Portishead Branch Line (MetroWest Phase 1)

9.15 ExA.CAH1.D3.V1 – Applicant's Oral Case and response to Representations at the Compulsory Acquisition Hearing 1 (CAH1)

The proposed Portishead Branch Line (MetroWest Phase 1) Order

Applicant's response to Representations at the Compulsory Acquisition Hearing Held on 4 December 2020 at 10am

Drawing: **HAM GREEN HIGHWAY
WORKS PLANS
SHEET 1 OF 3**

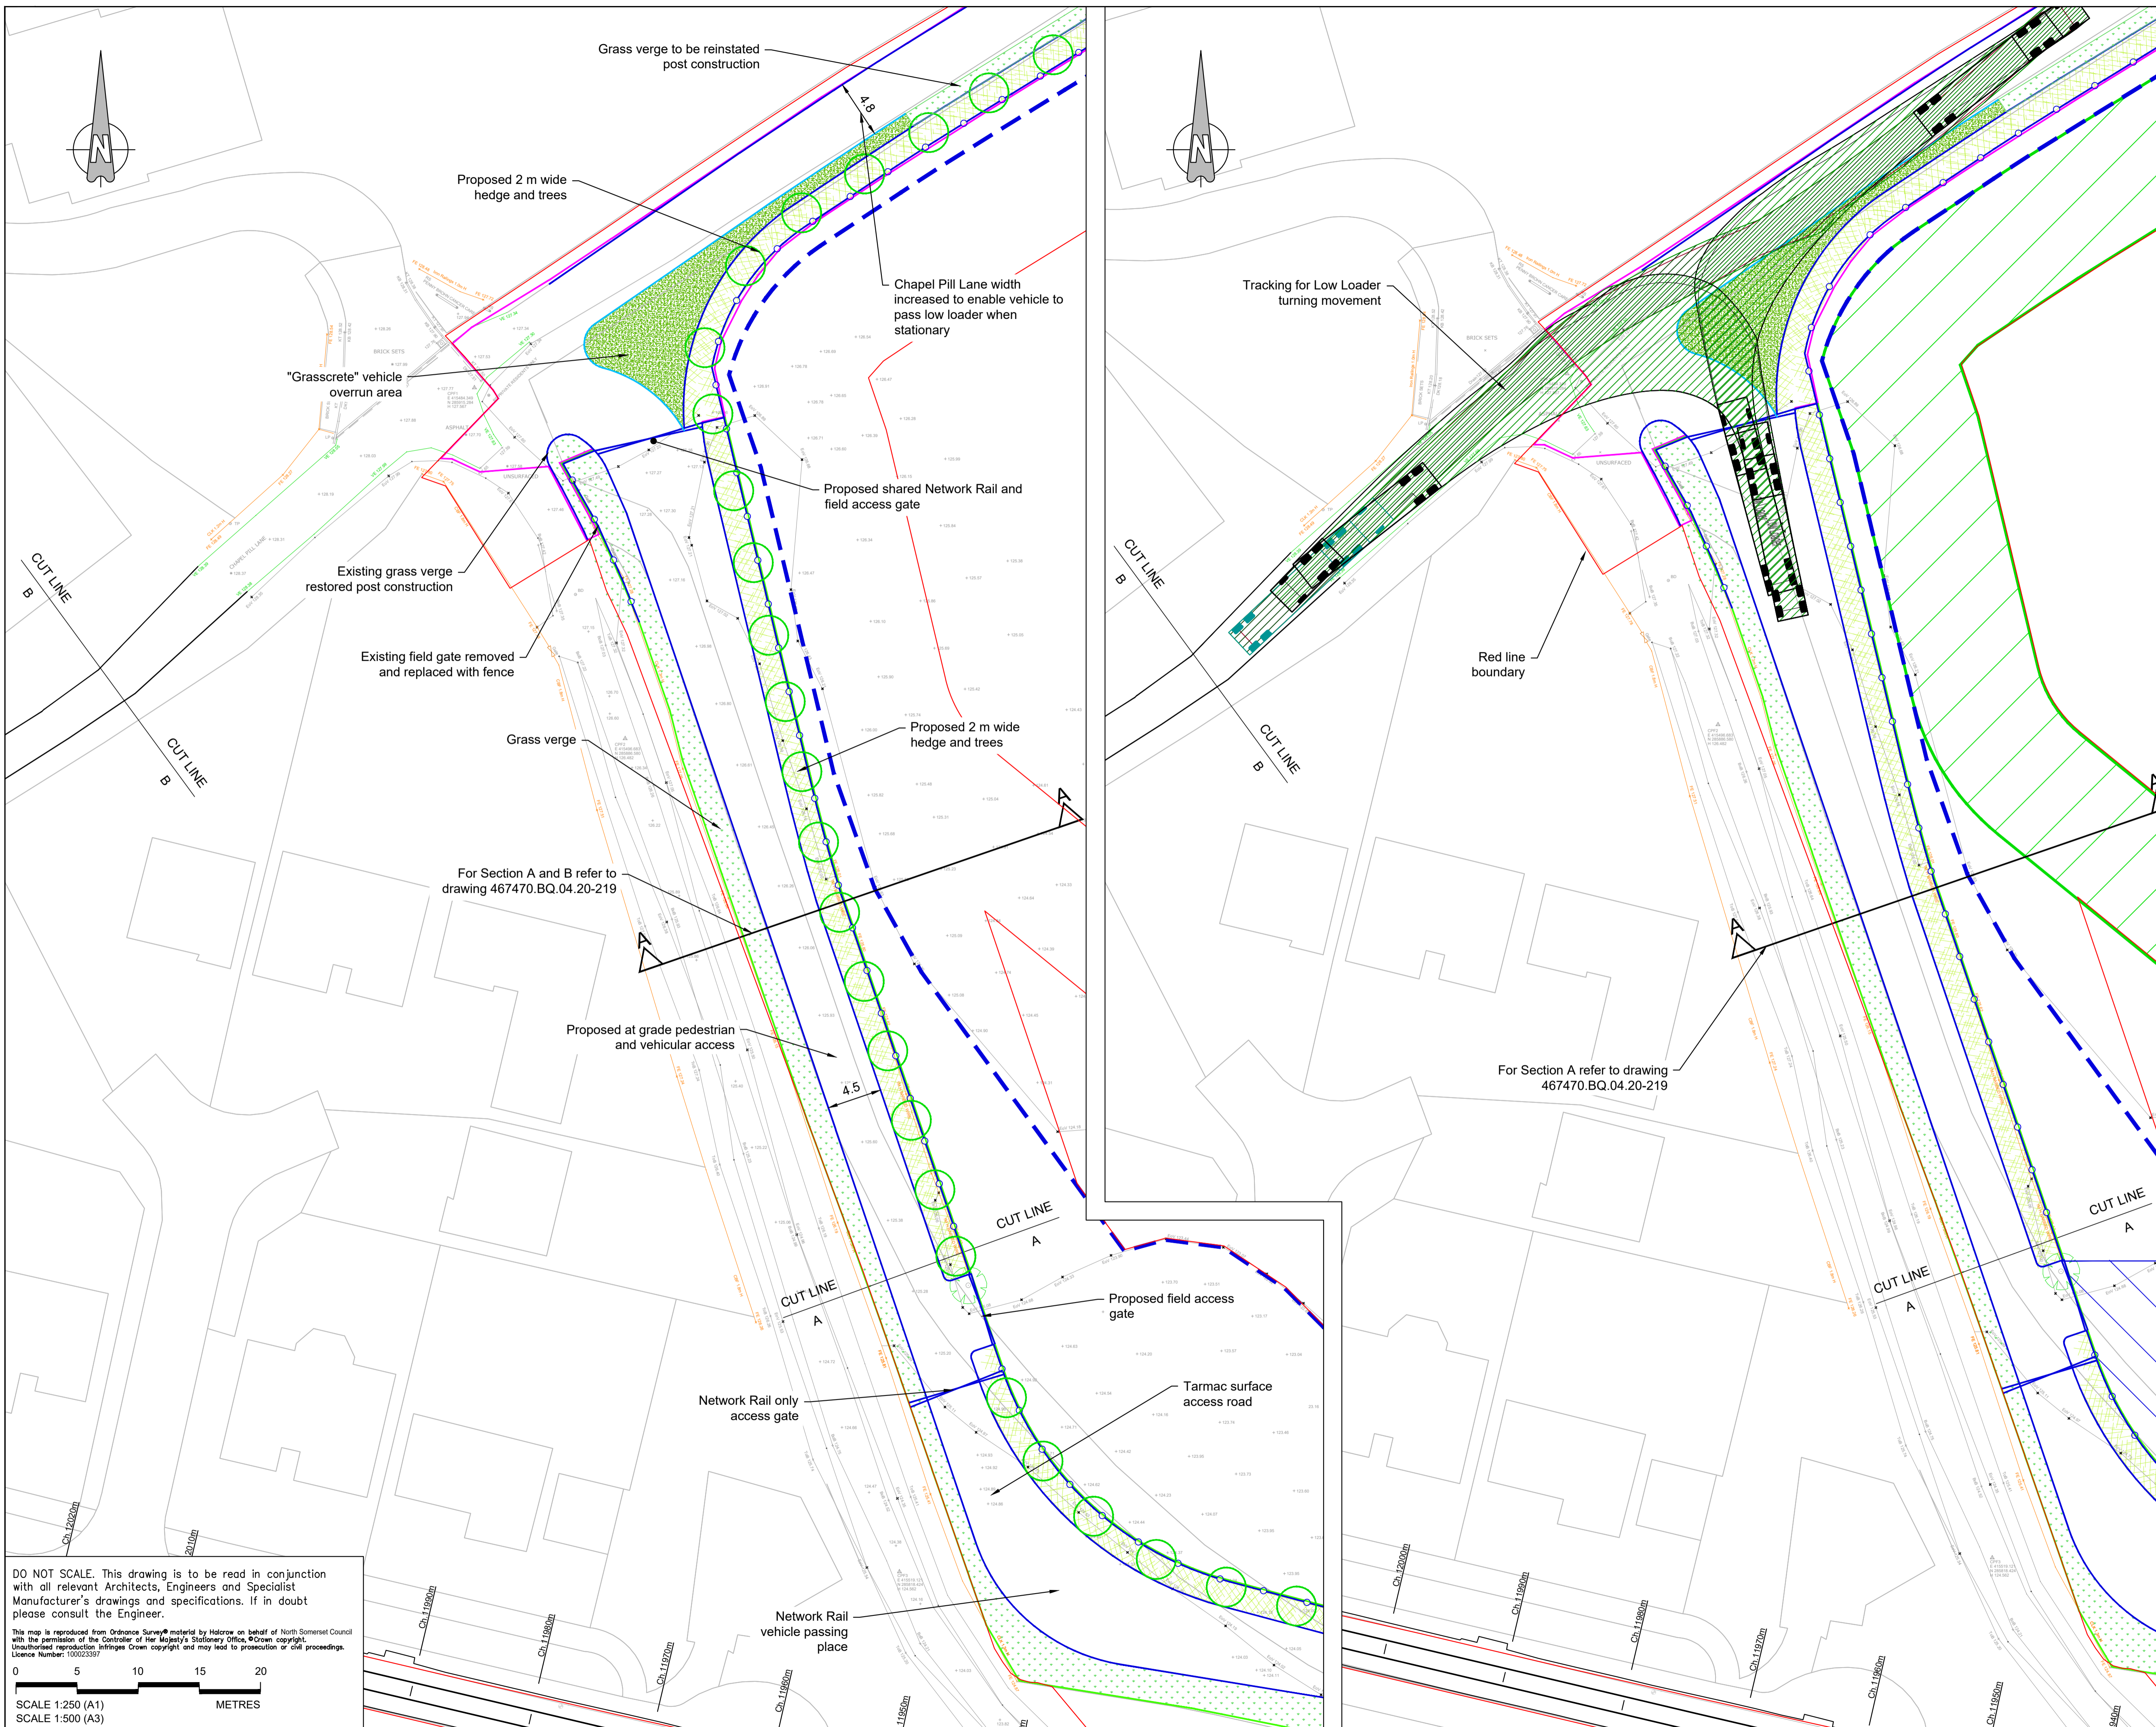
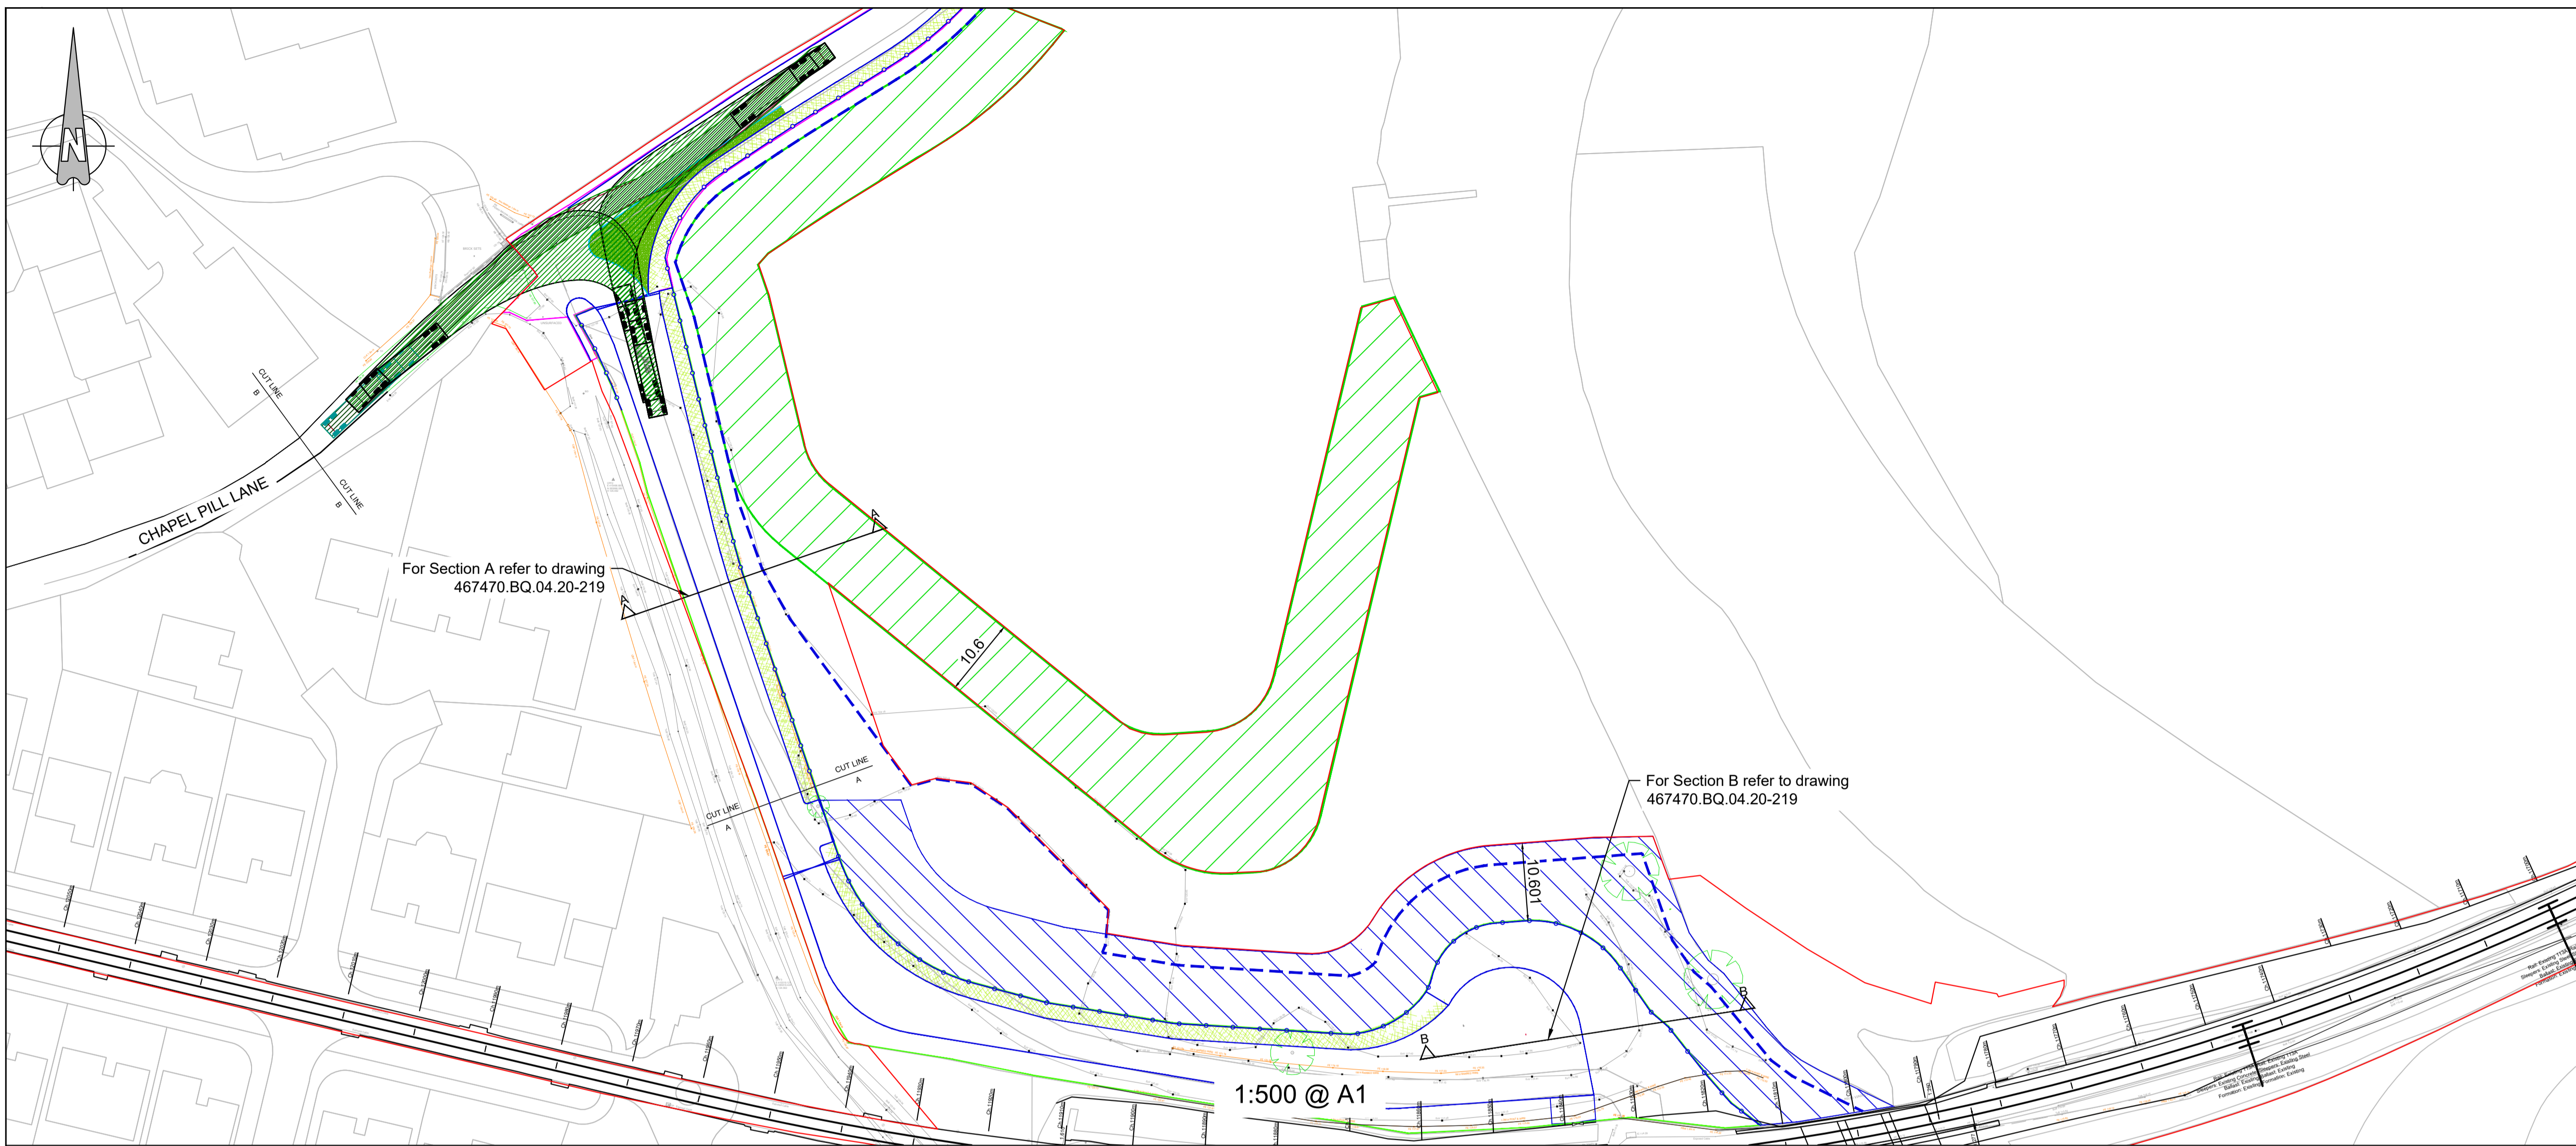
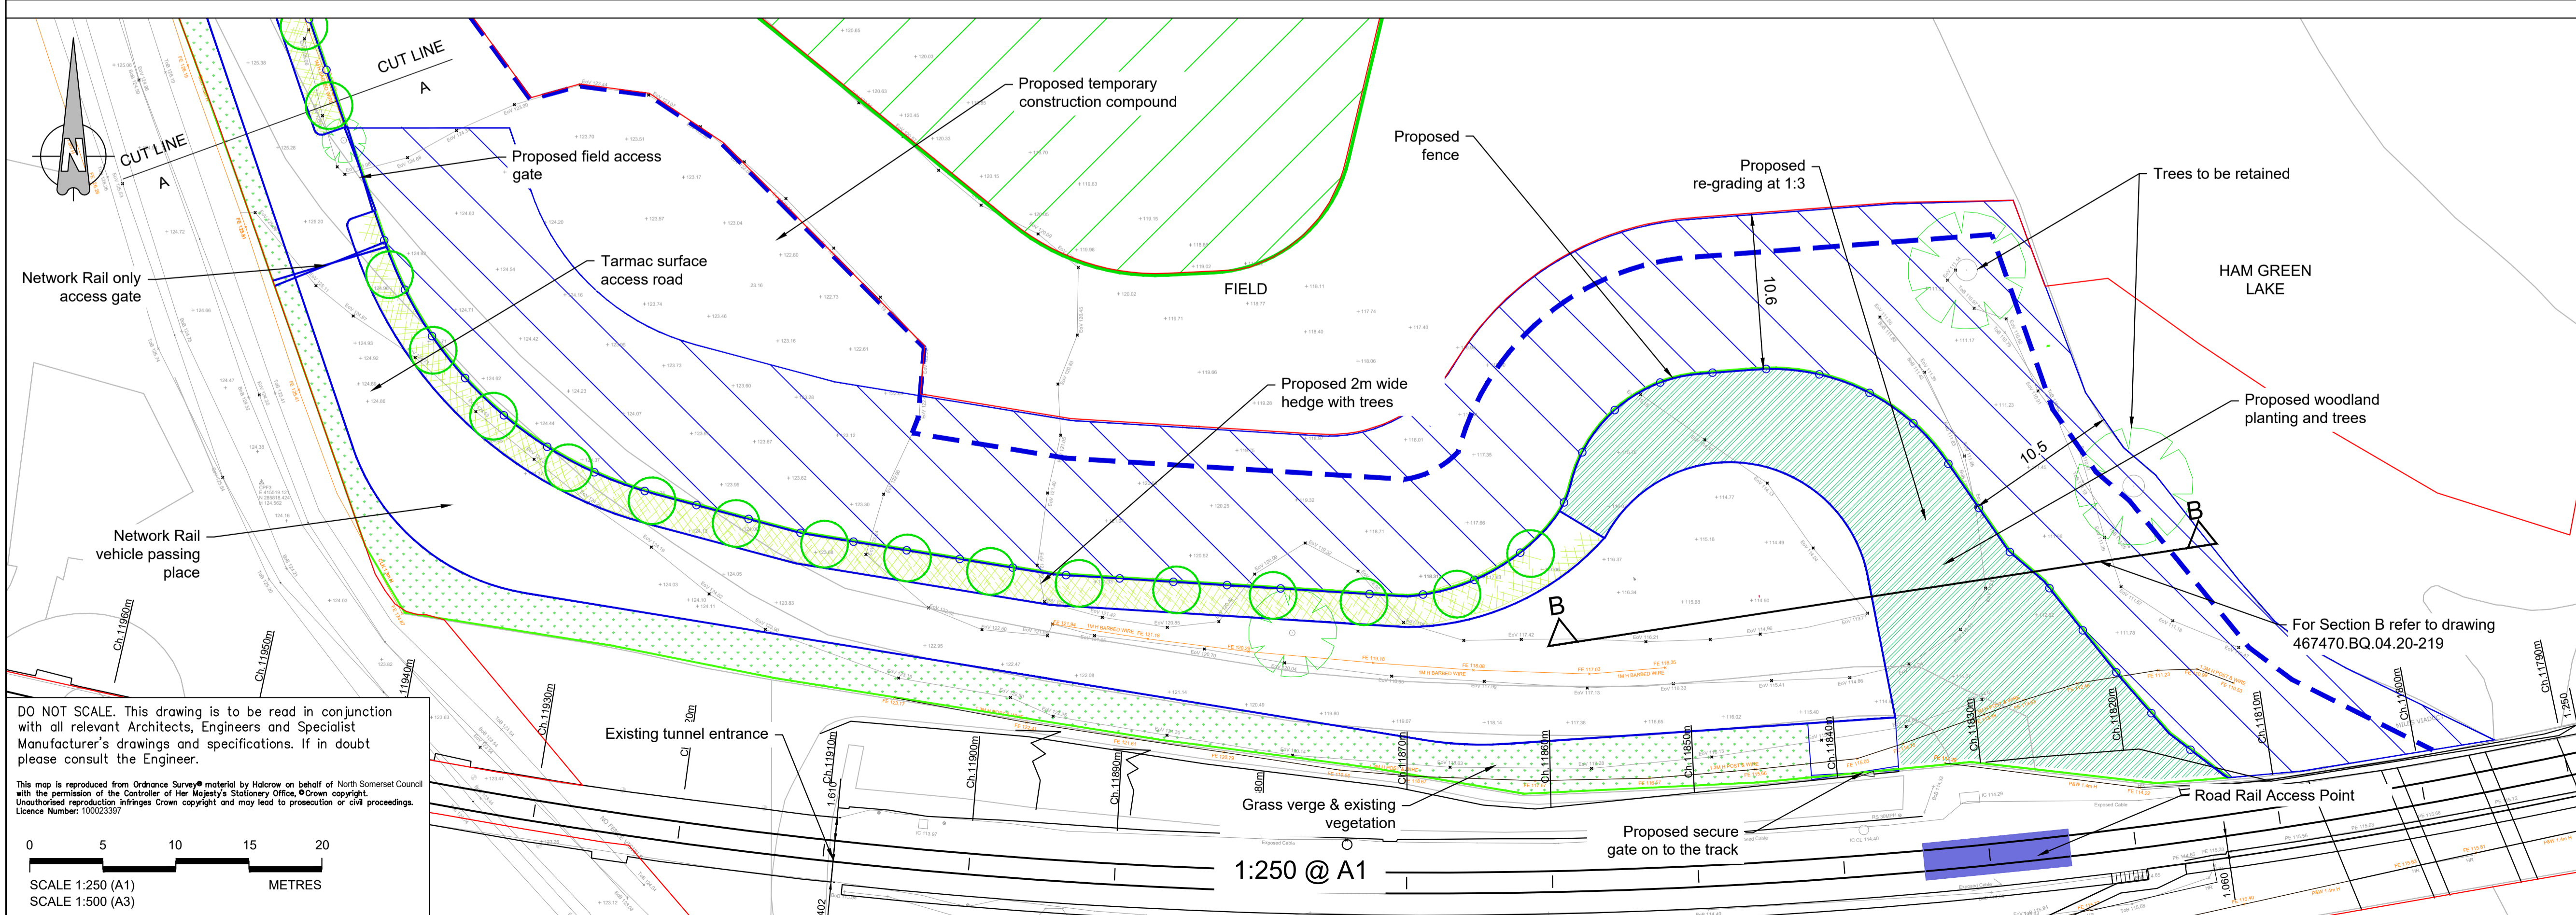
a)		In relation to Plots 01/211 and 01/250 – the Lake area of open space adjacent to Galingale Way which is being sought on a temporary basis. The ExA asked the Applicant to justify the extent of the land required as looking at the Land Plans against the EMP it does not quite match up.	The Applicant stated that there were two reasons for the extent of the land being acquired: There are two paths on either side of the pond and it is anticipated that access is required over both parts. The Applicant explained that it will need to access the railway line immediately to the north for Work No 7, the new bridge and the path leading to bridge, as well as for access to the railway to install fencing. Access is also required to the mitigation land. The Applicant explained that it didn't think it was appropriate to choose one or other of the paths. The Applicant also stated that given the configuration of Galingale Way it would not like	 The Applicant confirms its submissions at the CAH, save in regard to lighting columns (see last paragraph below). The two paths on either side of the pond are likely to be used for access to the construction works relating to the construction of the new pedestrian and cycle bridge (Work 7) and associated footpath. The paths may also be diverted in alignment on a temporary basis to tie in with the potential minor changes to the route for the crossing over the disused railway during works to construct Work no. 7. With regard to the pond itself, the Applicant's ecological contractors may release recovered amphibians to Galingale Way pond. Great Crested Newts (GCN) are

Ref:	Question/ Representation by:	Questions/Issues Raised at the CAH	Applicant's Response at the CAH	Applicant's Written Response
			to rule out some degree of management of the routes that are taken by the public, dealing with informal permissive right across the railway. Access would be by foot only The new rights being sought (01/252, 01/255,01/260 and 01/270) is to access the freehold land (01/299) that runs south from the railway and which is to be used for ecological mitigation purposes. The new rights and freehold land will not itself give an alternative route for access or re-routing public access. The Applicant added that in that area, additional street lamps are to be provided and a small amount of plant is required in order to install the street lamps. In addition, the open space may be scheduled to come over to the Council in any case as part of a historic s106 agreement.	already present in this pond so it is reasonable to be able to access this pond to allow safe release of GCN and other amphibians found within 1 km of the pond (it can only be for release of amphibians found within 1 km of the pond to avoid the need for disease screening for chytrid fungus, which can affect amphibian populations). In relation to the street lamps, the Applicant would like to clarify these comments. Street lamps were due to be installed in this area under a previous works design. Following design review it was decided that the street lamps would not be installed.
